Our reference: ECM Ref: 9719632  
Contact: Gavin Cherry  
Telephone: (02) 4732 8125

1 October 2021

**Response to Environmental Impact Statement: SSD-11070211 New Public School in Mulgoa Rise, Glenmore Park at 60-78 Deerubbin Drive, Glenmore Park and 1-23 Forestwood Drive, Glenmore Park**

Figure 9 – Proposed Pedestrian Fencing at Darug Avenue and Deerubbin Drive intersection

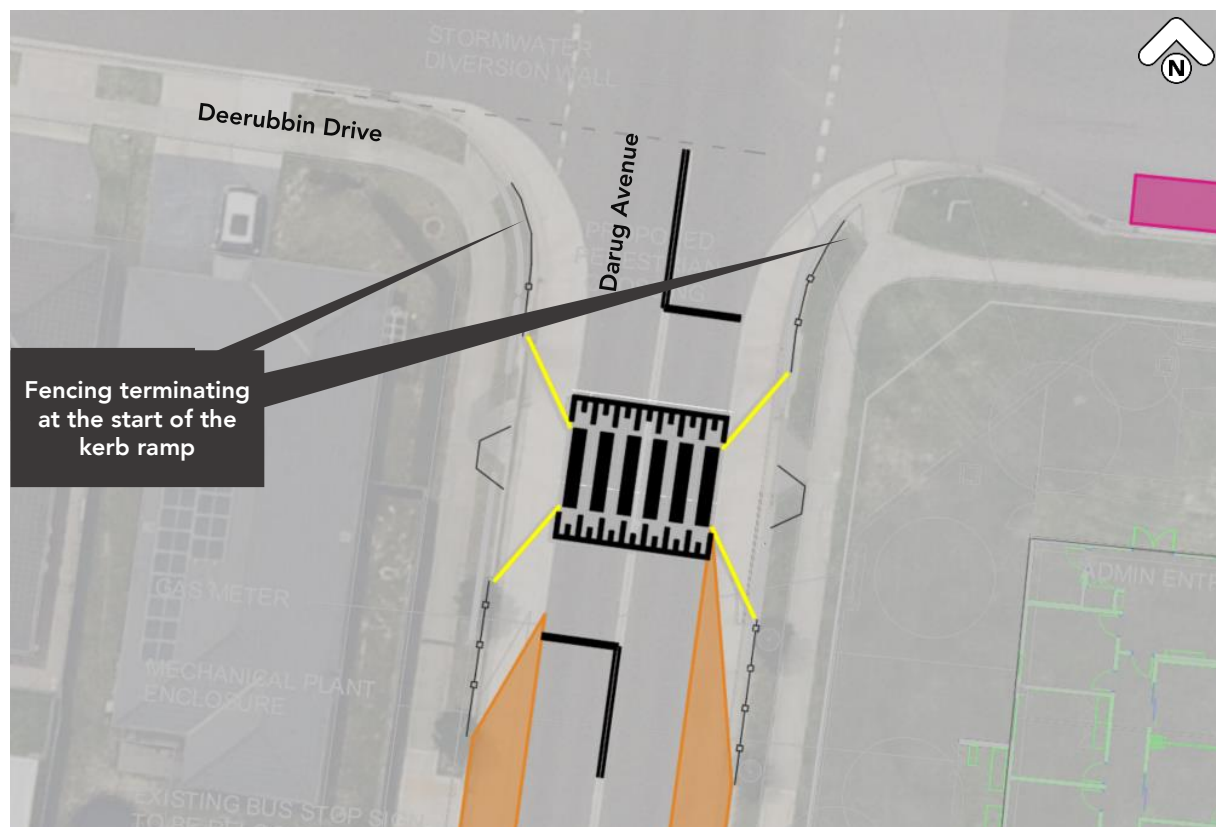
- ii) The proposed fencing at the corner of Darug Avenue and Deerubbin Drive should terminate at the start of the kerb ramp to cross Deerubbin Drive.

Figure 11 – Proposed Pedestrian Fencing at Darug Avenue

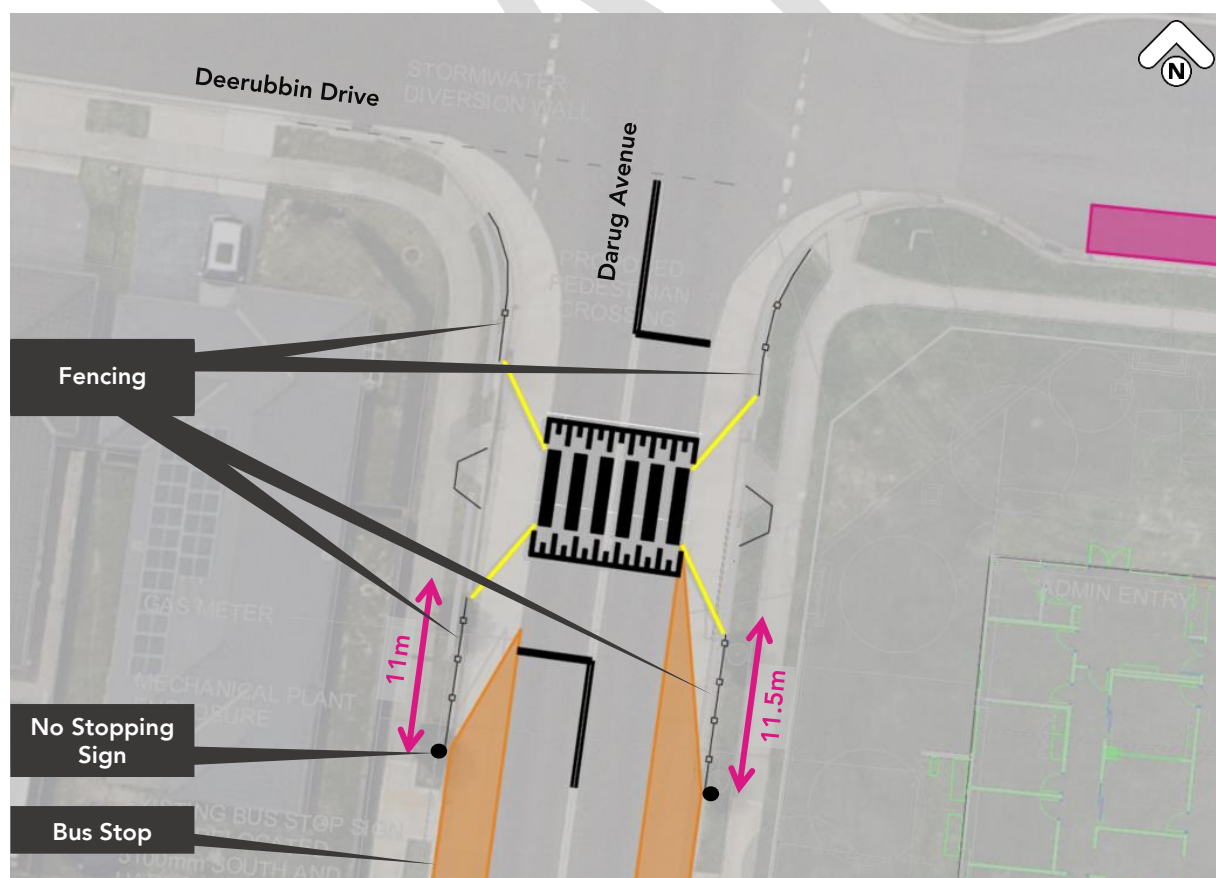
- v) There should also be pedestrian fencing provided on the verge at the back of the kerb, at the crossing 'No Stopping' zones on each side to direct pedestrian to the crossing.

Figure 18 – Bus Bays at Darug Avenue

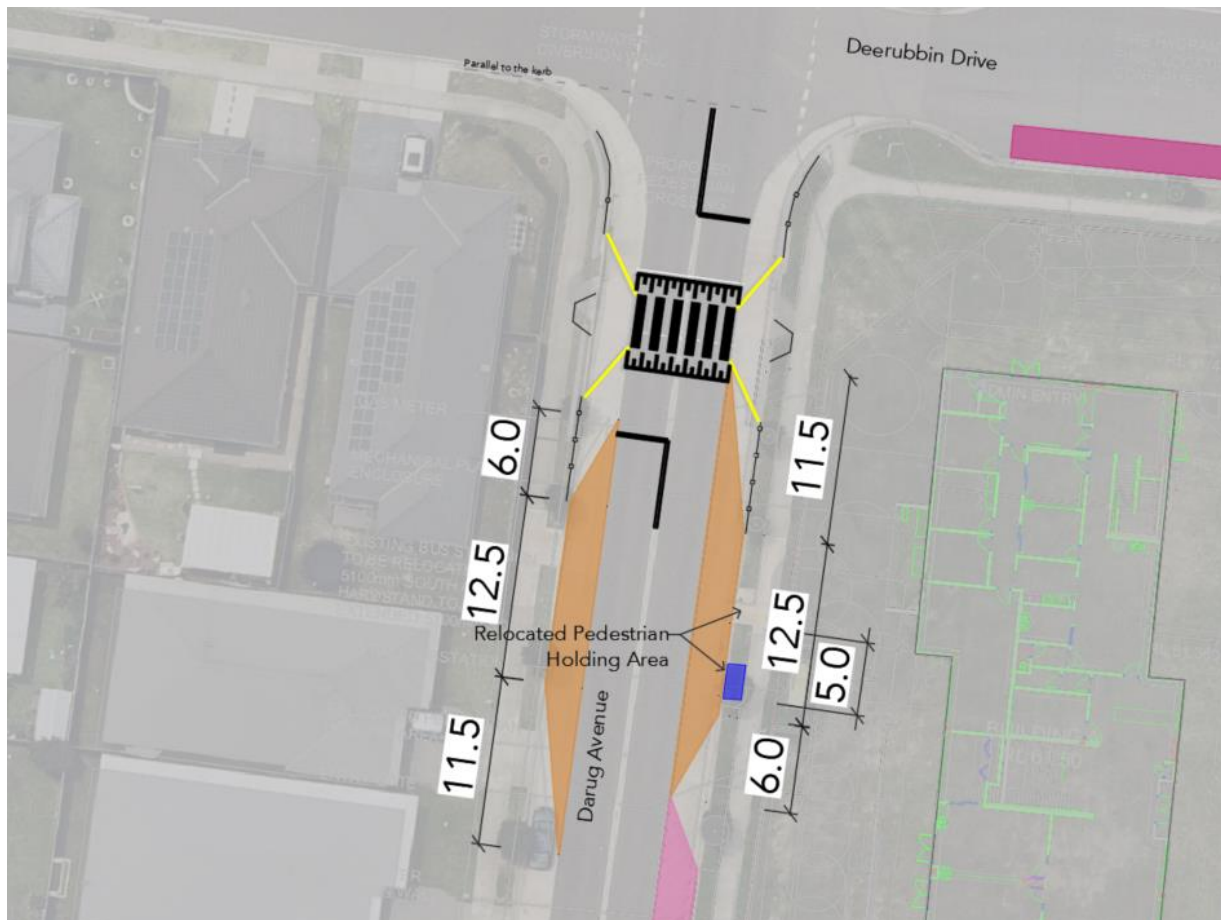
- i) The bus stops are to have the required TfNSW Complimentary Guide complying setbacks and sight line set backs from the proposed pedestrian crossing (which is required to be relocated further south as set out in following dot points).
